Office of
Environment
& Heritage

RE: REVIEW OF EXHIBITED ENVIRONMENTAL ASSESSMENT FOR MANDALONG SOUTHERN EXTENSION PROJECT (SSD-5144)

REVIEW OF EXHIBITED ENVIRONMENTAL ASSESSMENT FOR MANDALONG SOUTHERN EXTENSION PROJECT (SSD-5144)

FIGURE 3.4

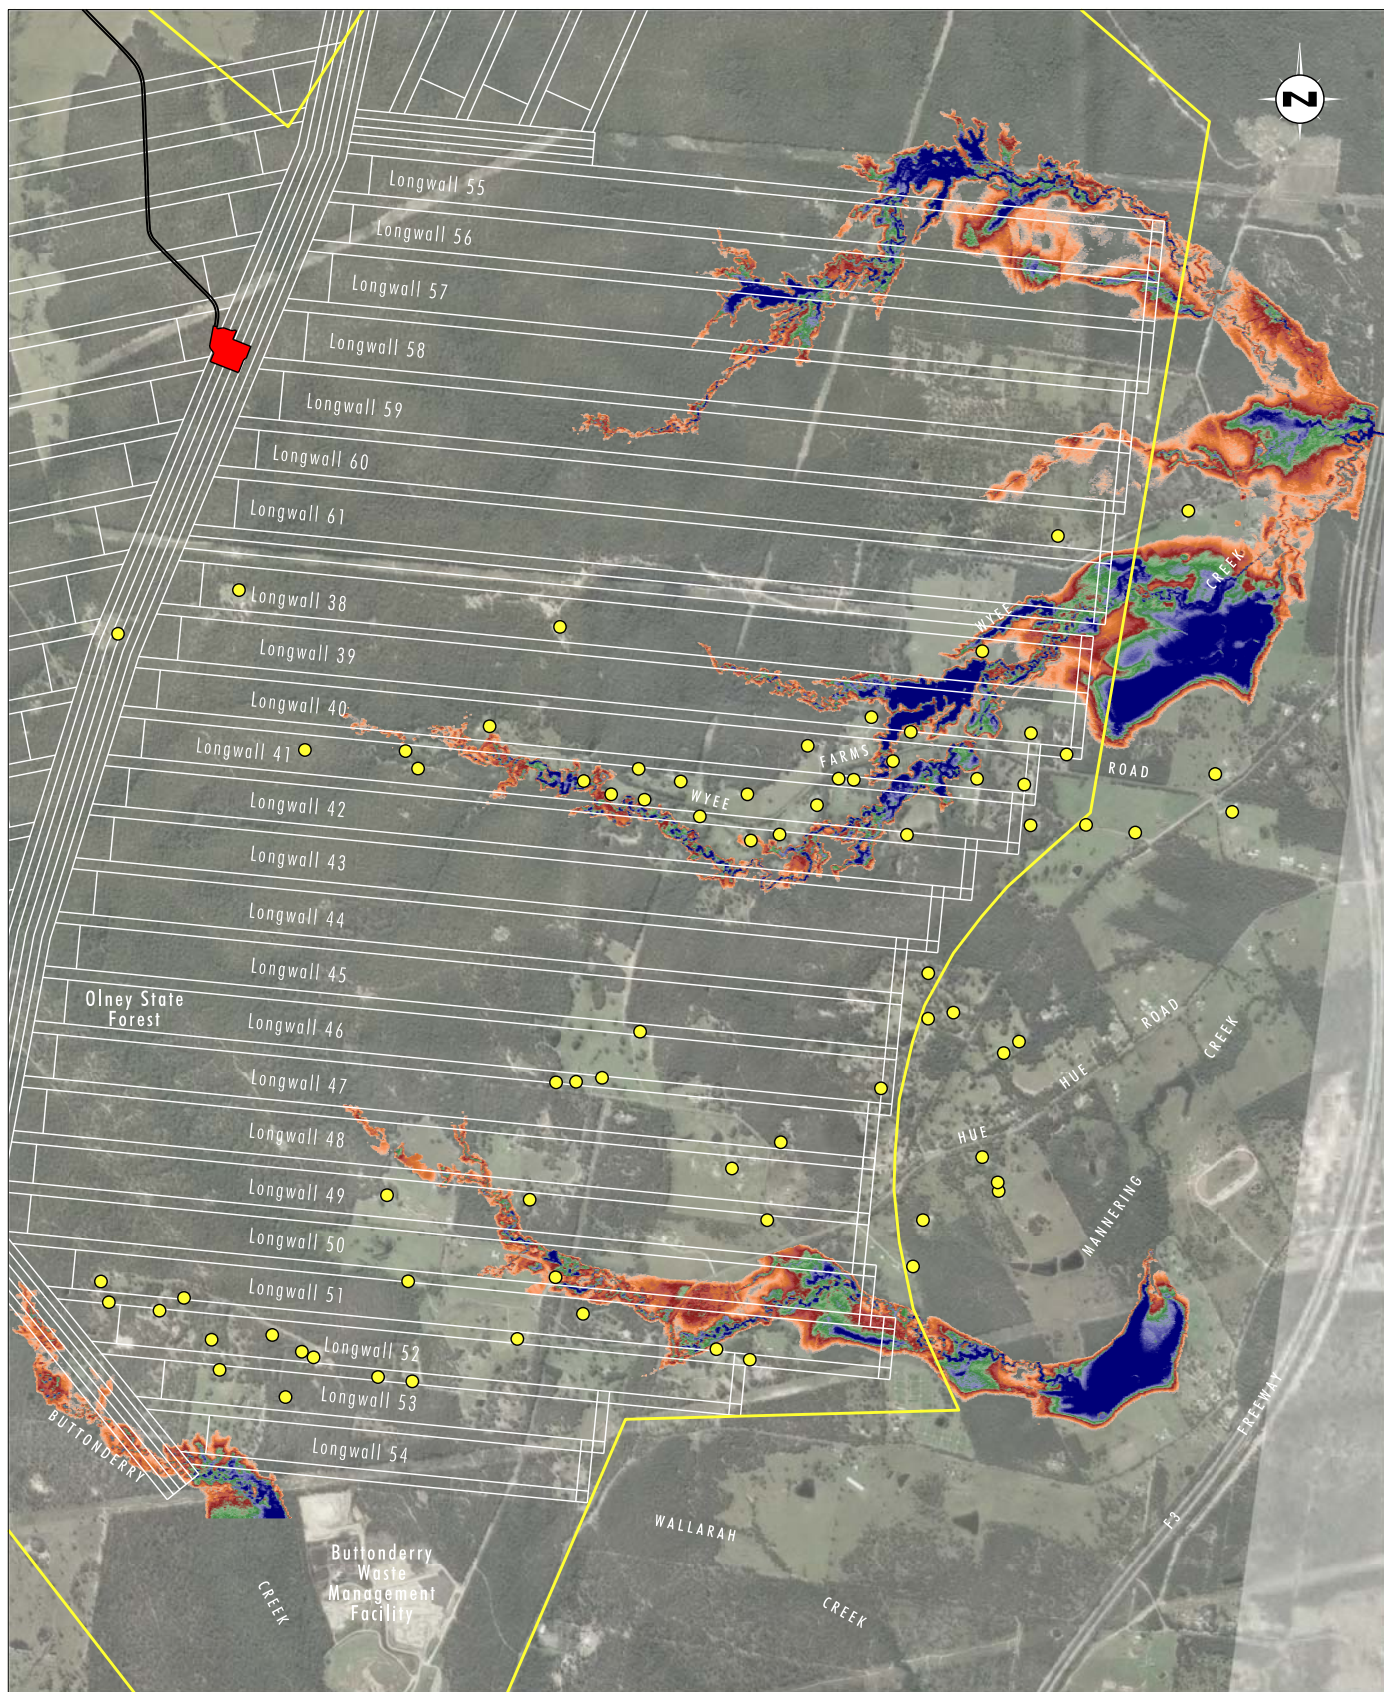
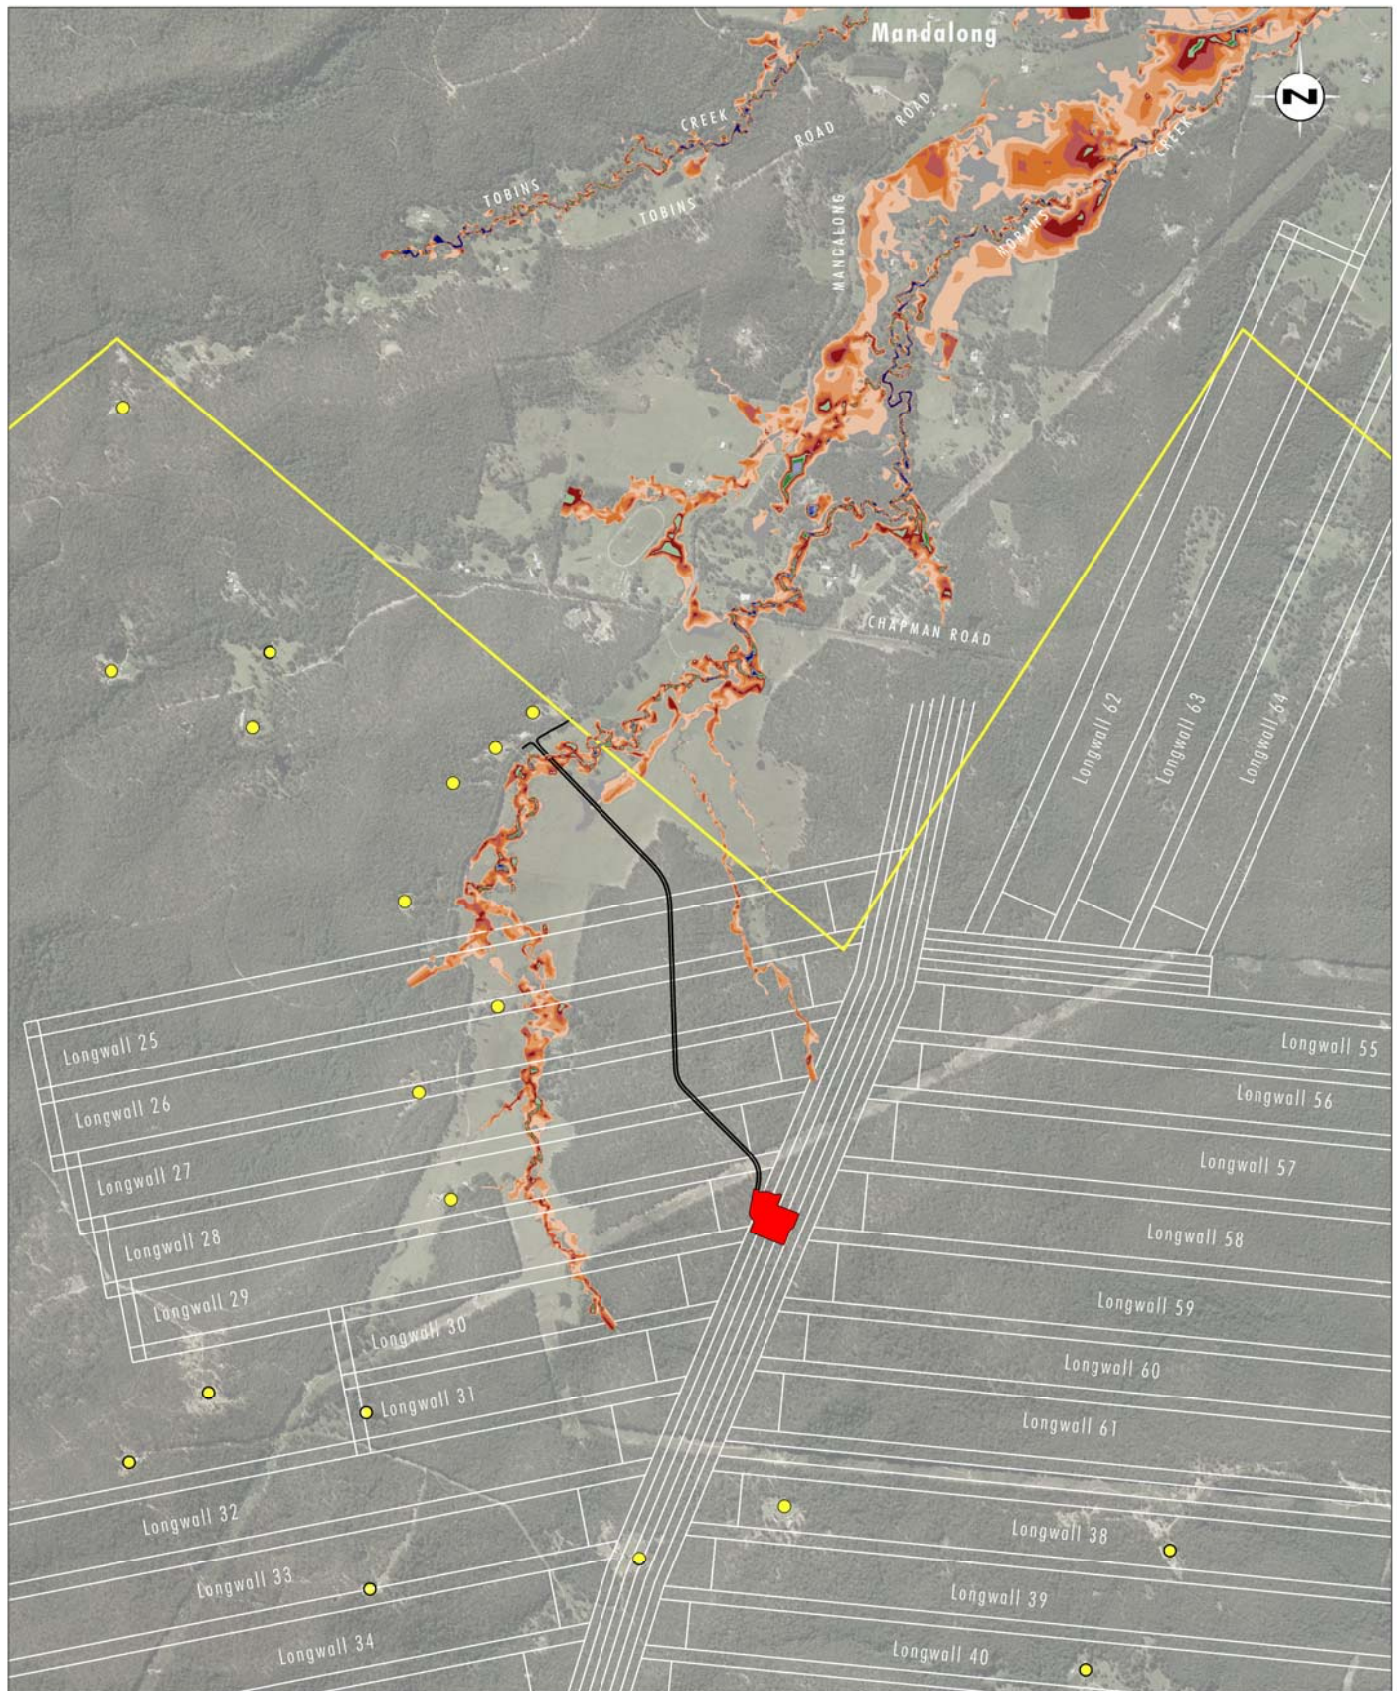
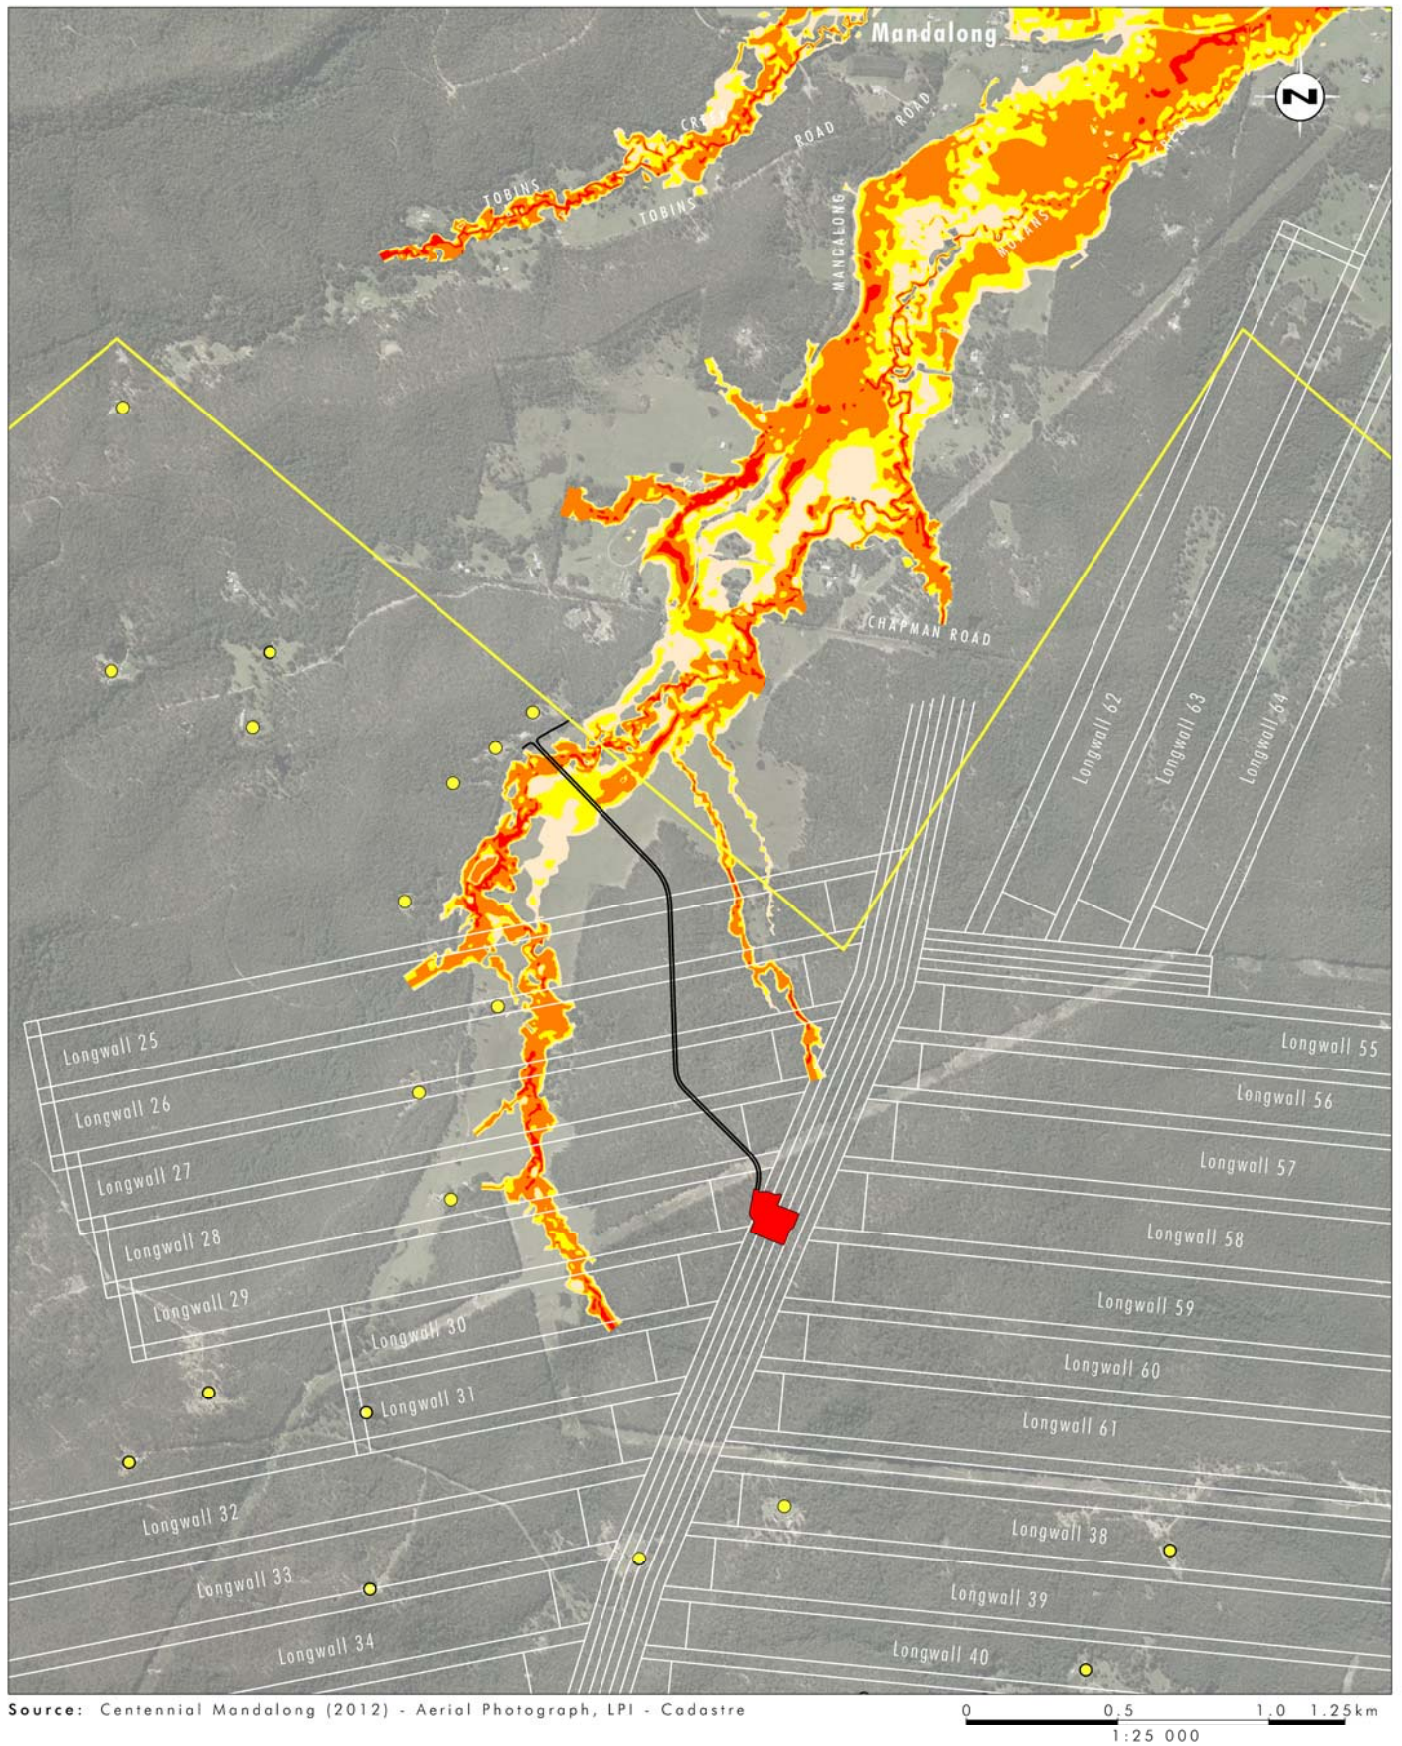
5. Virtually no gauging data for almost all 3rd order and above streams above the expanded proposal. This will hinder any assessment of impact (e.g. loss of water) in these major streams.

OEH notes that the term 'ephemeral' has not been defined appropriately or applied appropriately to the third order and above streams above the project area. A *perennial* stream or *perennial* river can be defined as "a stream or river (channel) that has continuous flow in parts of its bed all year round during years of normal rainfall". 'Perennial' streams are contrasted with 'intermittent' streams which normally cease flowing for weeks or months each year, and with 'ephemeral' channels that flow only for hours or days following rainfall. During unusually dry years, a normally perennial stream may cease flowing, becoming intermittent for days, weeks, or months depending on severity of the drought. The boundaries between perennial, intermittent, and ephemeral channels are indefinite, and subject to a variety of identification methods (but they all require some assessment of actual flow).

OEH questions why the EIS uses the phrase "*It is understood that watercourses ... are ephemeral*" when the stream description provided clearly aligns with an intermittent stream. If the Wyee gauging data is used, monitoring over the period November 1958 to July 1979 identified zero flows on approximately 25% of the days with recorded flows. Again this is indicative of an intermittent stream and not a stream that flows "*only for hours or days following rainfall*". A recent visit to Morans Creek by OEH also identified flows in the upstream drainage line despite a week since rainfall fell in the area. Based on an analysis of flows for the Wyee Creek records (Stn211001), if as little as 0.5ML/day is lost as a result of undermining, Wyee Creek would cease to flow more often than it was measured to have flowed (75% of the time over the period November 1958 to July 1979).
